Subject: Goulburn Poultry Processing Mixed Use Development (SSD 9143) – Response to Submissions (RTS)

Detailed advice to DPE Planning & Assessment regarding the Goulburn Poultry Processing Mixed Use Development (SSD-9143) – RTS

NOTE: SPEL STORMSACKS TO COLLECT RUNOFF FROM ALL HARDSTAND IMPERVIOUS AREAS.

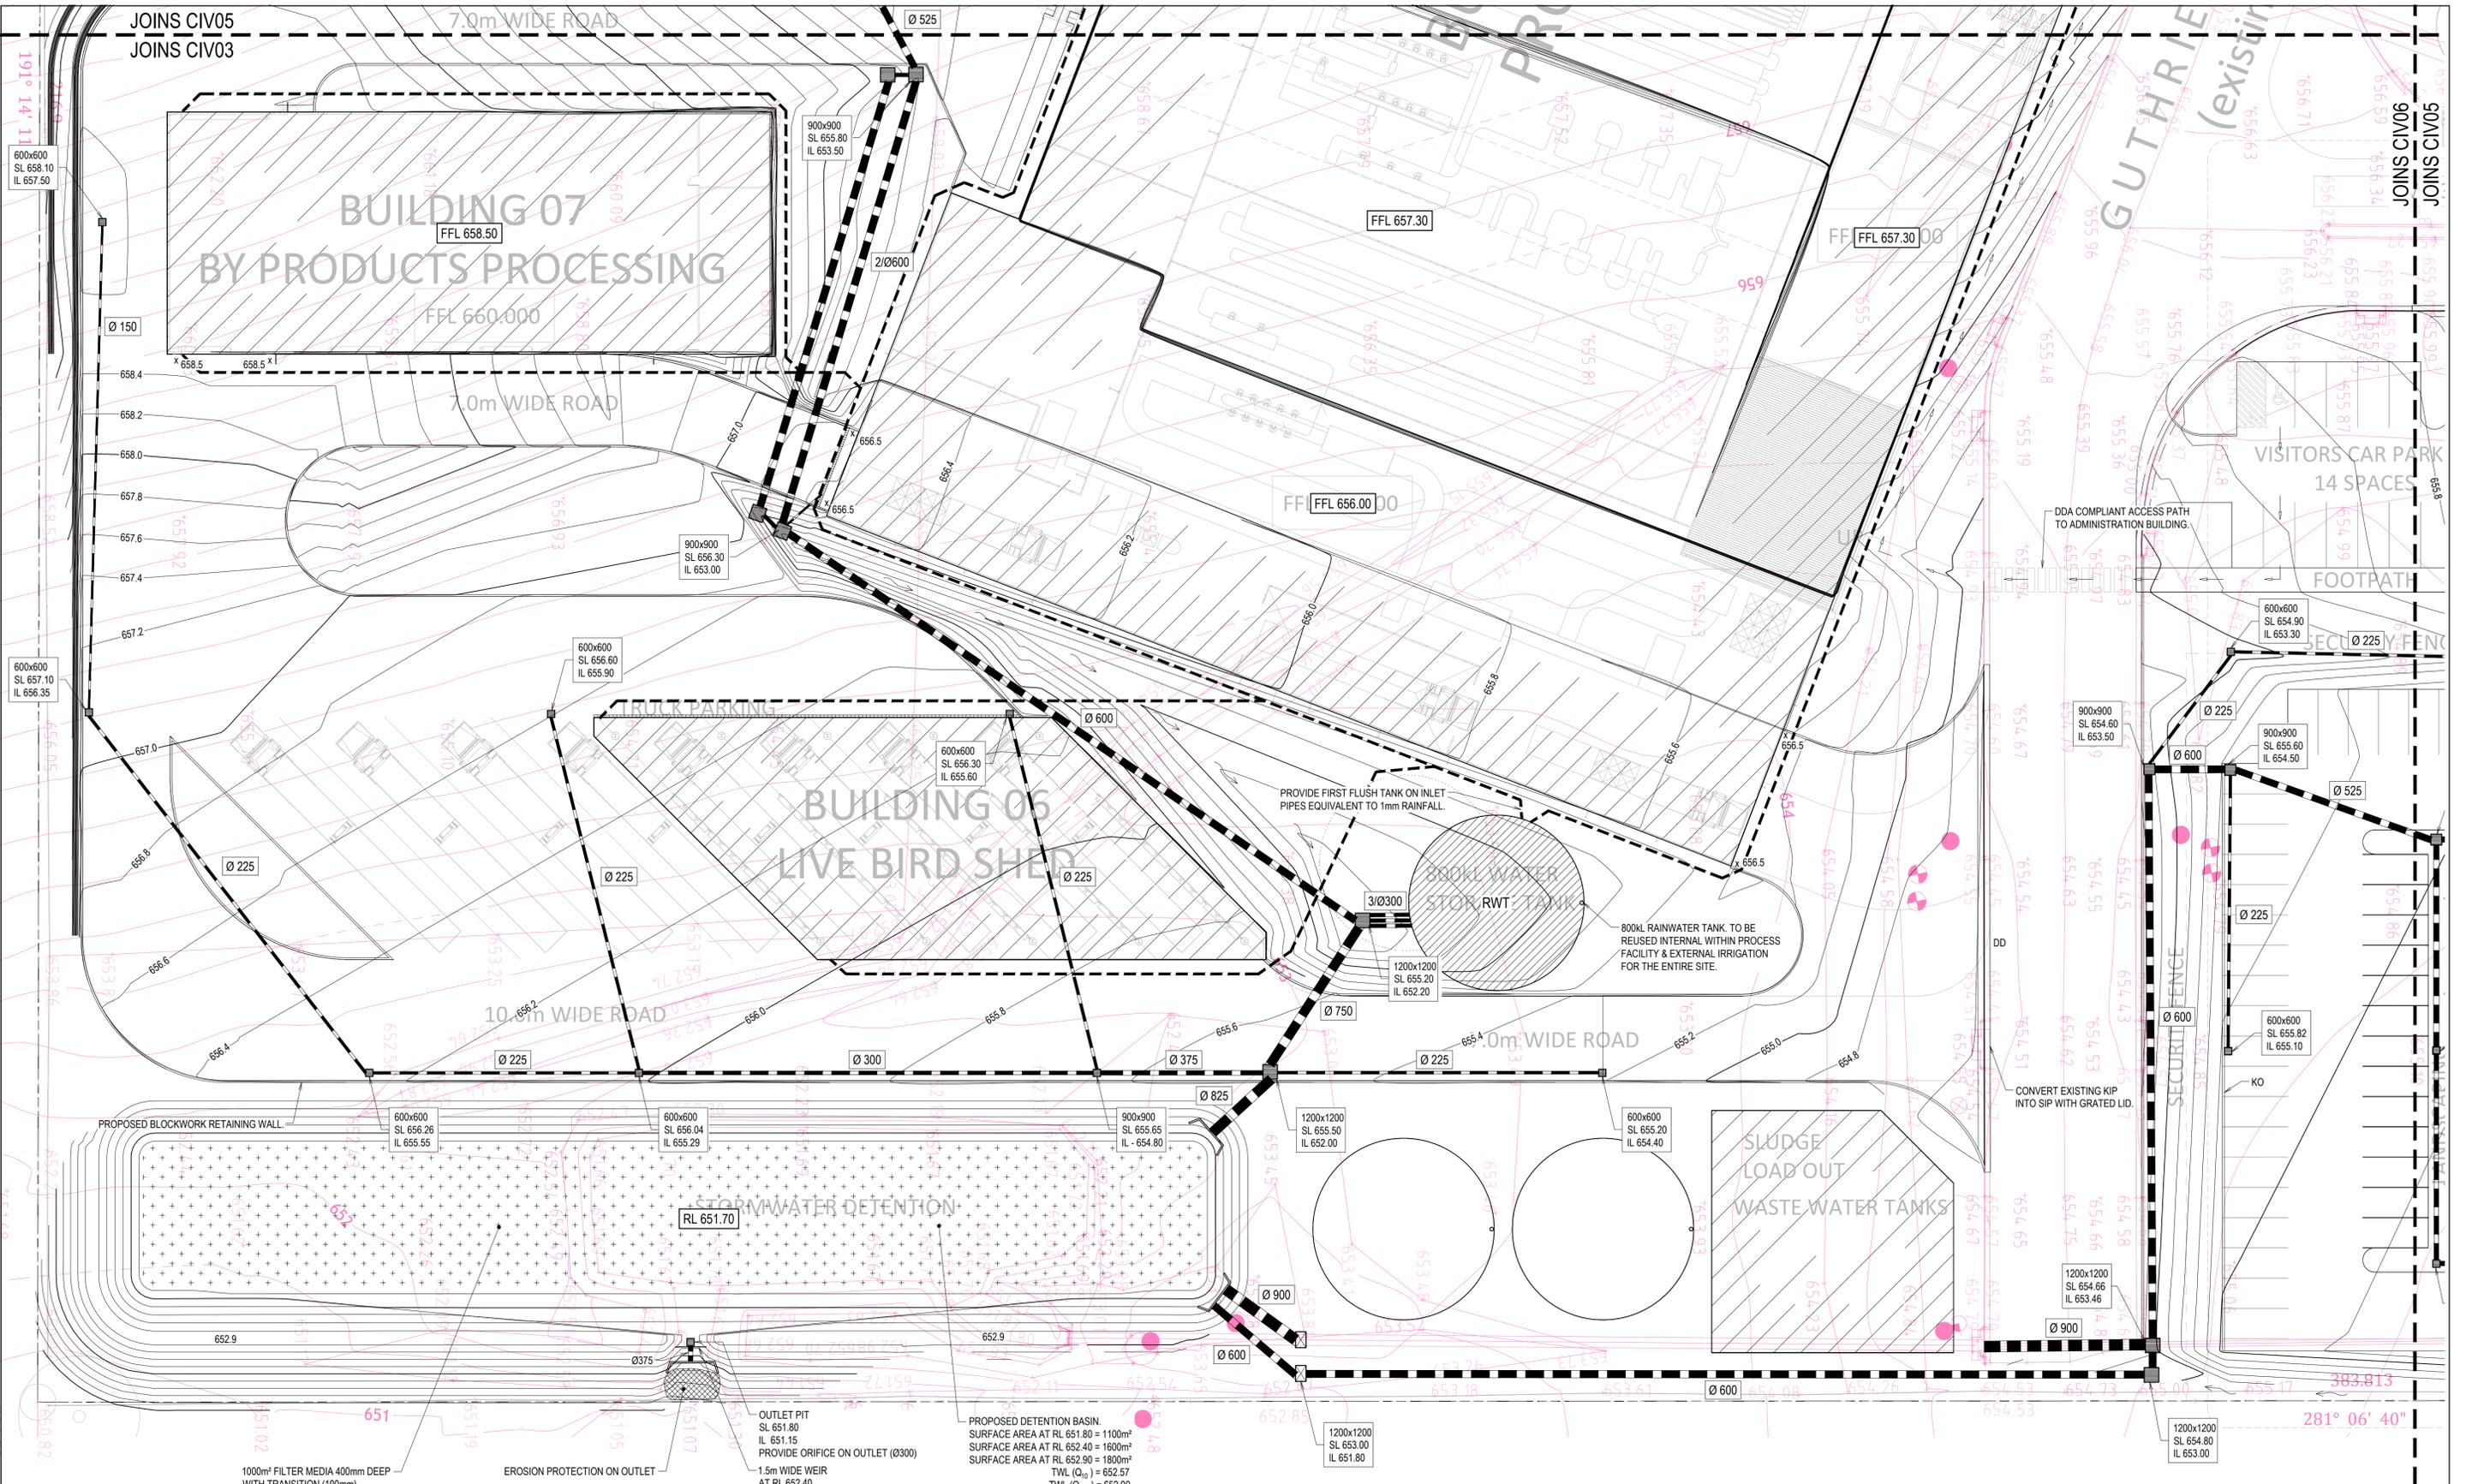
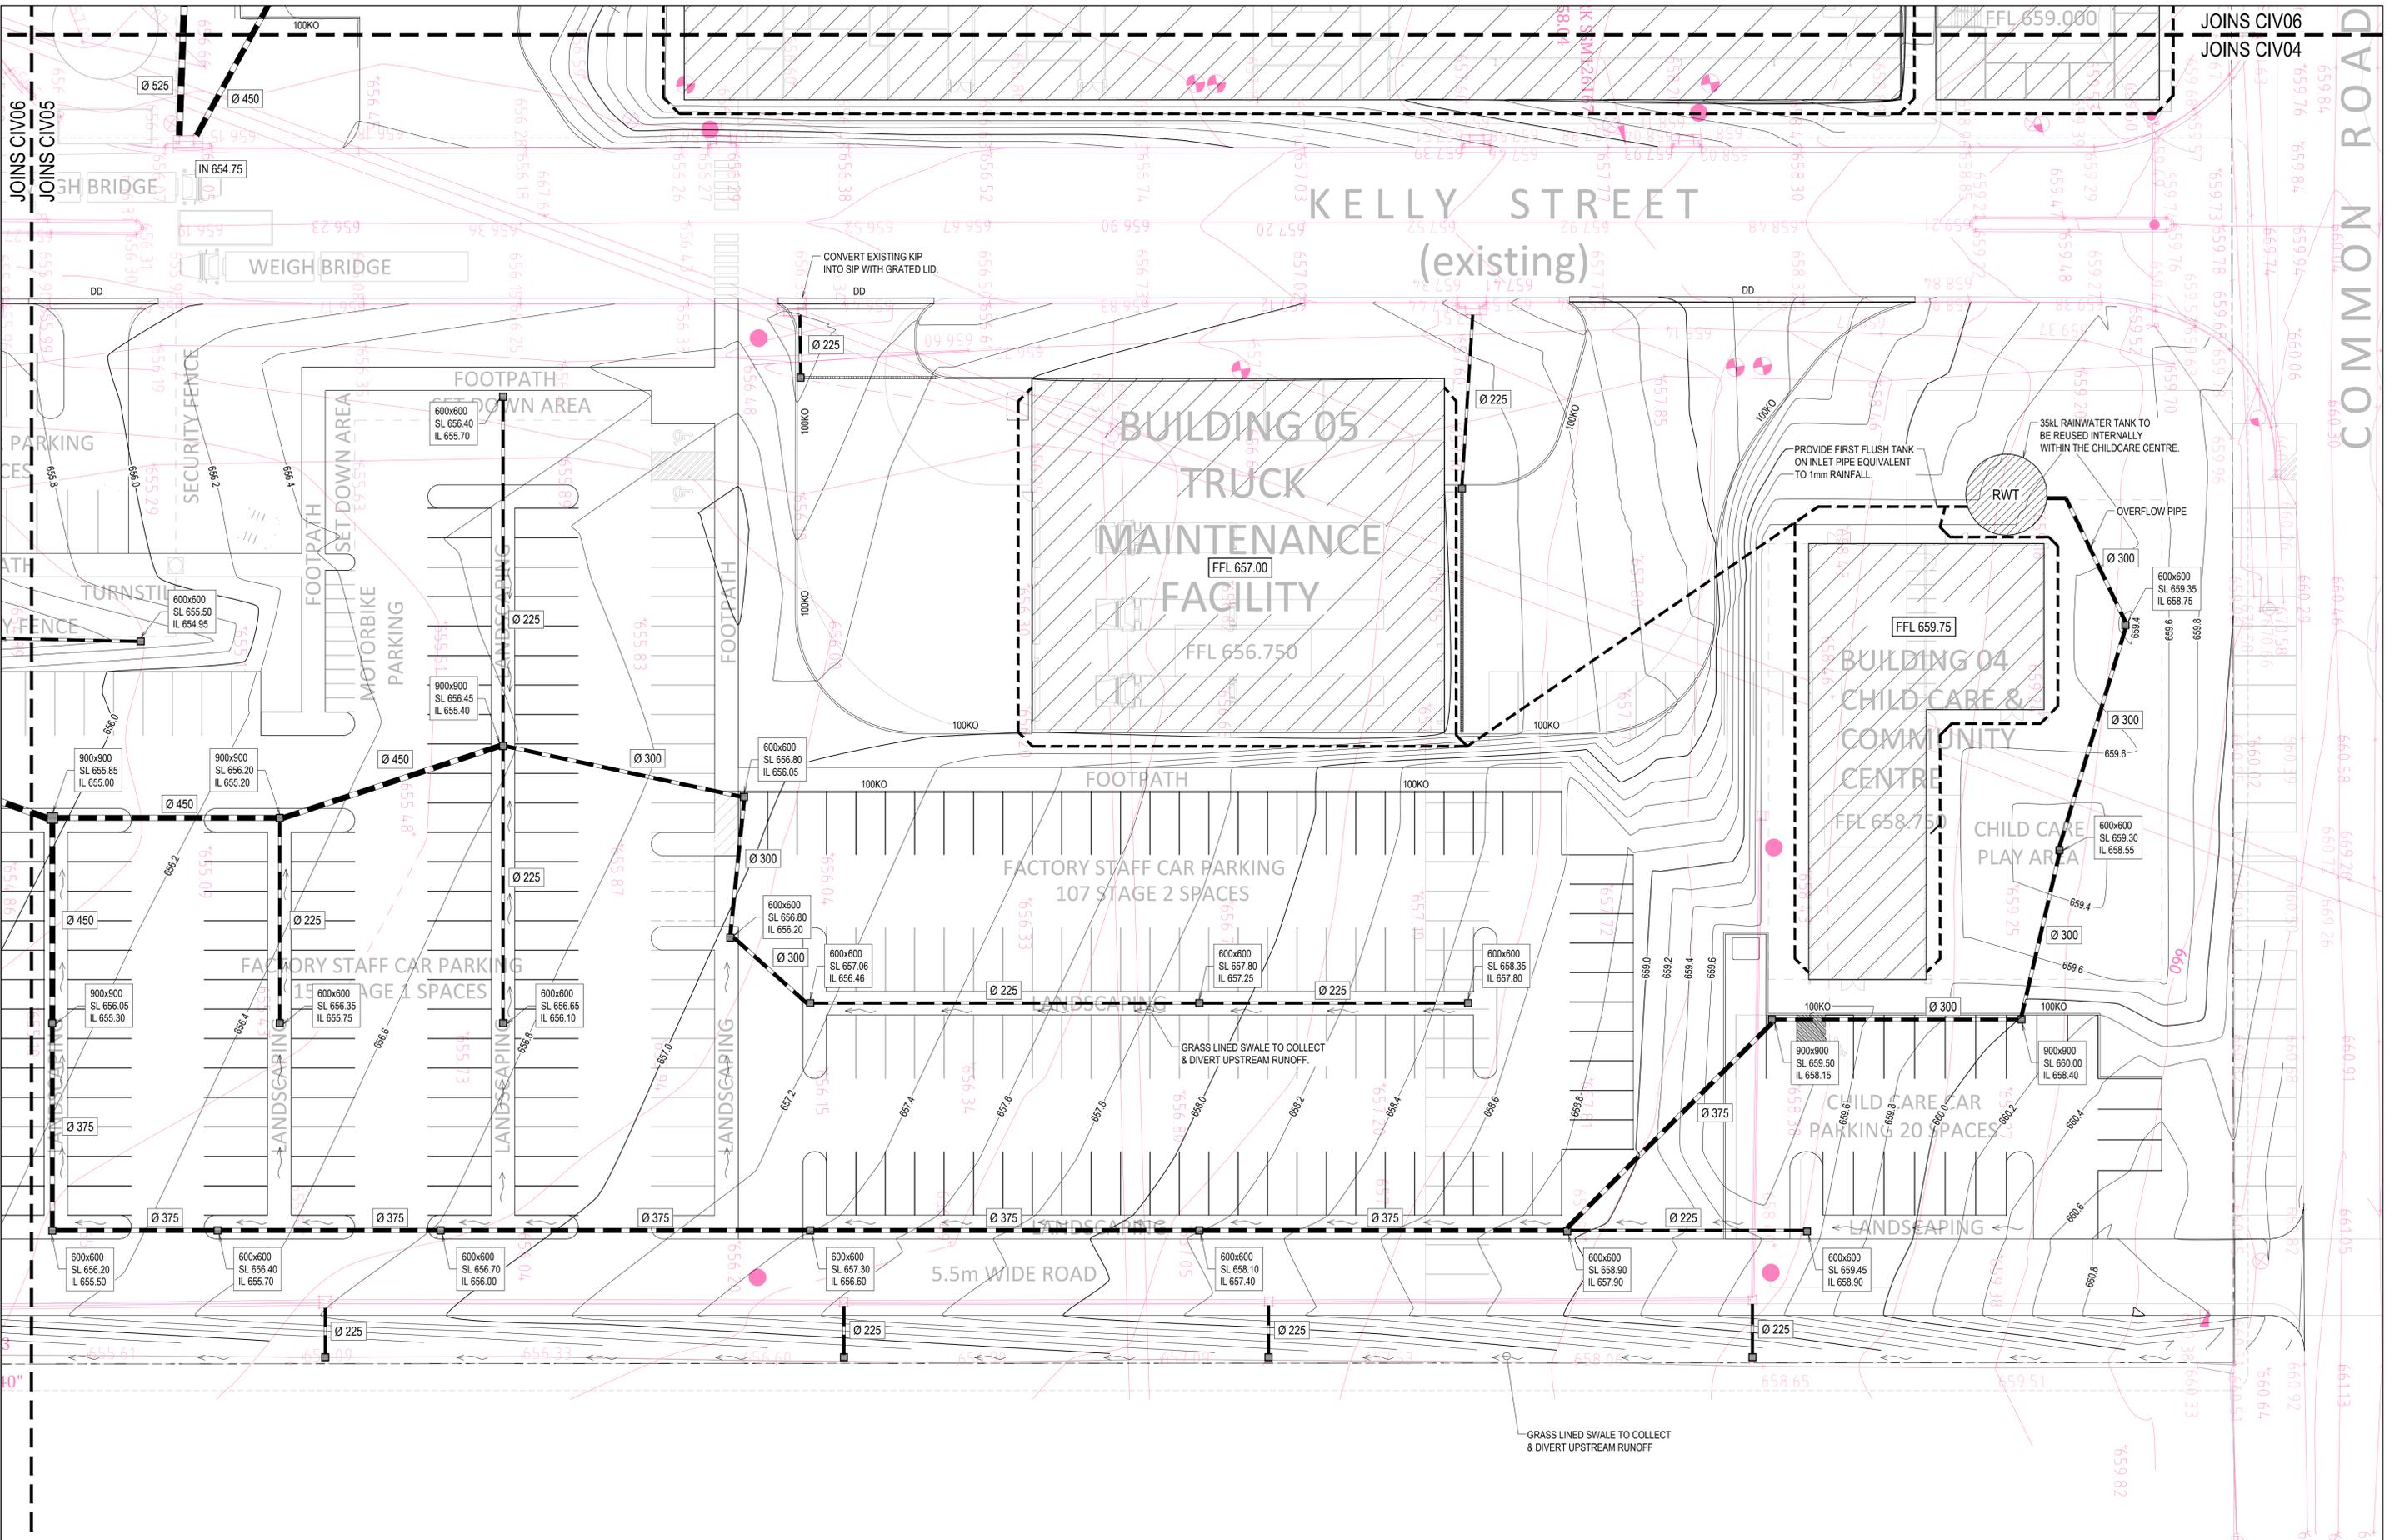
- Appendix B of the RTS provided civil drawings which indicated approximately 10cm of water may be stored in the base of the detention basin. This storage volume is between the base of the basin and the lowest outlet. The capture of runoff in dams on minor streams needs to be considered for licensing under Harvestable Rights or by holding sufficient entitlement in a WAL for water take.

The design of the on-site detention basin needs to ensure that the volume of water that can be permanently held is within the Harvestable Rights for the property or the volume removed from the basin is accounted for by a Water Access Licence (WAL) in the relevant water source.
